Our ref: STH20/00172/01
Contact: Andrew Lissenden 0418 962 703
Your ref: SSD-10326042

REQUEST FOR SECRETARY'S ENVIRONMENTAL ASSESSMENT REQUIREMENTS (SEAR'S) – NEW PRIMARY SCHOOL - LOT 3 DP 1179941 APRASIA AVENUE, GOOGONG

TfNSW has completed a review of the information provided (report by GHD dated October 2020 with reference 12515242 and the Department of Planning, Industry and Environments draft SEAR's) and notes:

Figure 1: Site Plan (received 9 June 2021)

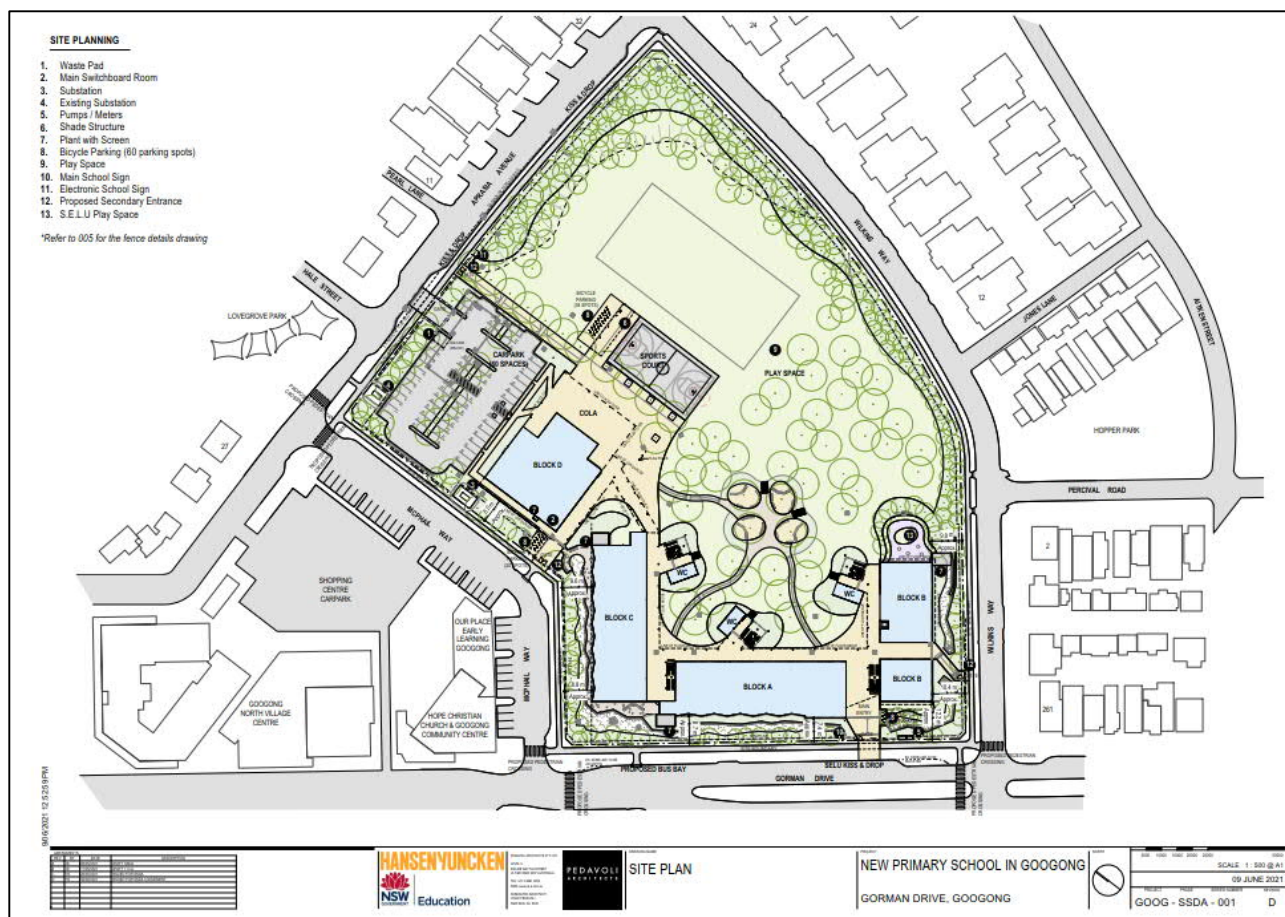
- e) Assess and justify the number of access points required to and from the school. TfNSW notes that the concept site plan (Figure 2.1 in the GHD report) shows five pedestrian access points to the school. TfNSW would encourage limiting the number of access points to three (e.g. one on each frontage except McPhail Way). An initial review has indicated that as there is a pedestrian and vehicle generator on McPhail Way with the shops and car parking. An entrance on this side could cause safety concerns as well as increased congestion. TfNSW also suggests that the main entrance to the school be provided via Wilkins Way and not Gorman Drive. This is due to crossings and main entries being avoided on sub arterial roads or roads with greater than 2,000 annual average daily traffic (AADT);

- f) Reduce/consolidate the number of children's crossings. TfNSW notes that the concept/site plan provided shows 6 crossings. Any crossing provided should be strategically located to be safe and accommodate desire lines. Where possible raised zebra crossing shall be used with no crossings installed at junctions. Details are also required on how the crossings proposed meet the numerical warrants detailed in the TfNSW Supplement *Austroads Guide to Traffic Management Part 6*;

Figure 20: Kiss & Ride Location

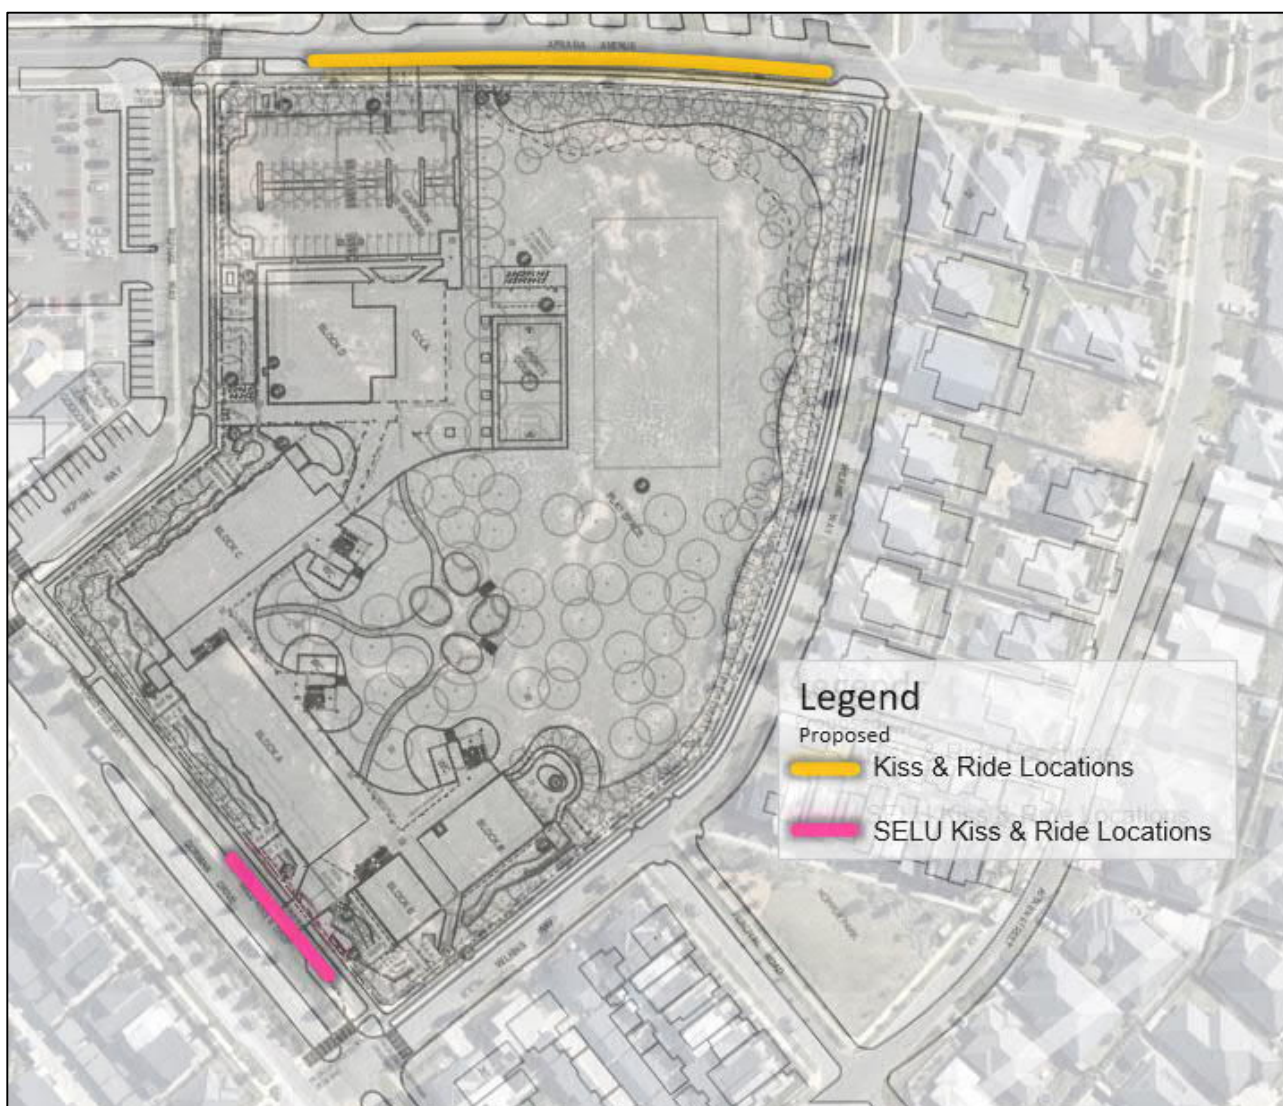
- h) Detail the drop-off and pick up zones for cars as well as buses including an assessment of the impacts on the adjoining road network. TfNSW suggests that Wilkins Way should be indented and should be the preferred drop and pickup for parents. The bus bay/zone should be off road where possible otherwise indented and should be of sufficient size to cater for the maximum number of buses. Swept paths for the bus bay should be provided to demonstrate that all buses using the area can manoeuvre in and out independently of other buses using the area. Details on bus shelters/weather protection for public transport users should be provided;
